Community Submission: SSD-96272465

Residential Development with In-fill Affordable Housing, 11-23 Rangers Avenue, Mosman

Date: 17 December 2025

Figure 4 Existing traffic flows – Rangers Avenue / Park Avenue

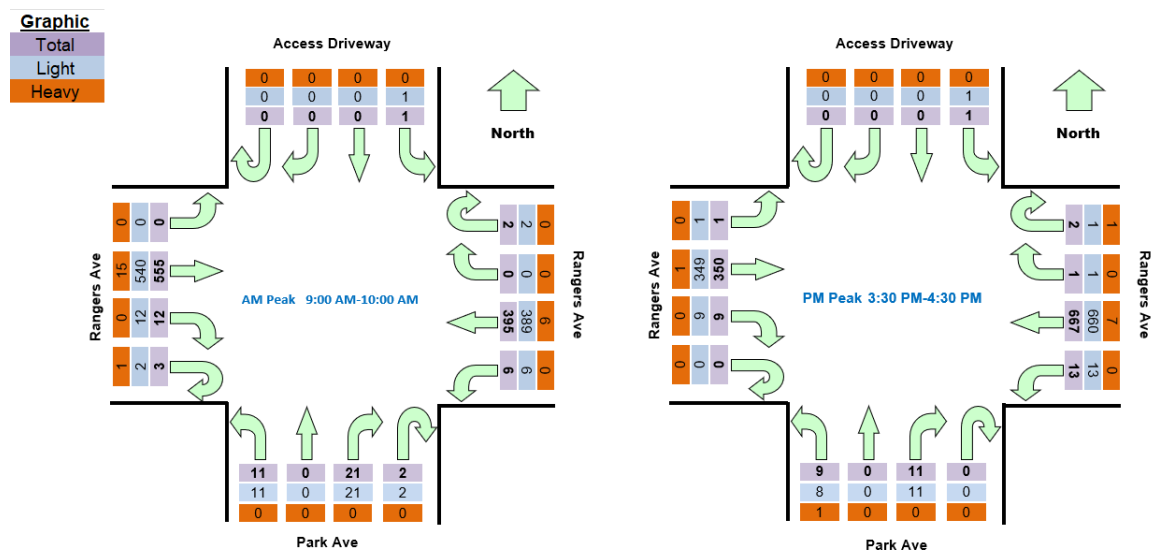
The TIA states that traffic counts were undertaken at the Rangers Avenue / Park Avenue intersection during:

- **AM Peak: 9:00am - 10:00am**
- **PM Peak: 3:30pm - 4:30pm**

Critical flaw: The AM survey period of 9:00-10:00am **completely misses the school drop-off peak**, which typically occurs between **8:00-9:00am**. This is precisely the period when Rangers Avenue experiences its highest weekday traffic volumes and parking pressure. The survey timing appears designed to capture commuter traffic patterns, not the actual peak conditions experienced by local residents.

1. **Revised traffic surveys** to be conducted during actual peak periods:
 - Weekday AM: 7:30am - 9:30am (capturing school drop-off)
 - Weekend: Saturday 9:00am - 12:00pm and Saturday/Sunday 3:00pm - 6:00pm
2. **Cumulative traffic assessment** considering all approved and proposed developments on Rangers Avenue
3. **Construction Traffic Management Plan** to include:
 - No heavy vehicle movements during school drop-off/pick-up (8:00-9:15am, 2:30-3:45pm on school days)
 - Restrictions on Saturday morning construction vehicle access
 - Community liaison officer and complaints hotline
4. **Resident parking scheme contribution** to fund parking management measures on Rangers Avenue
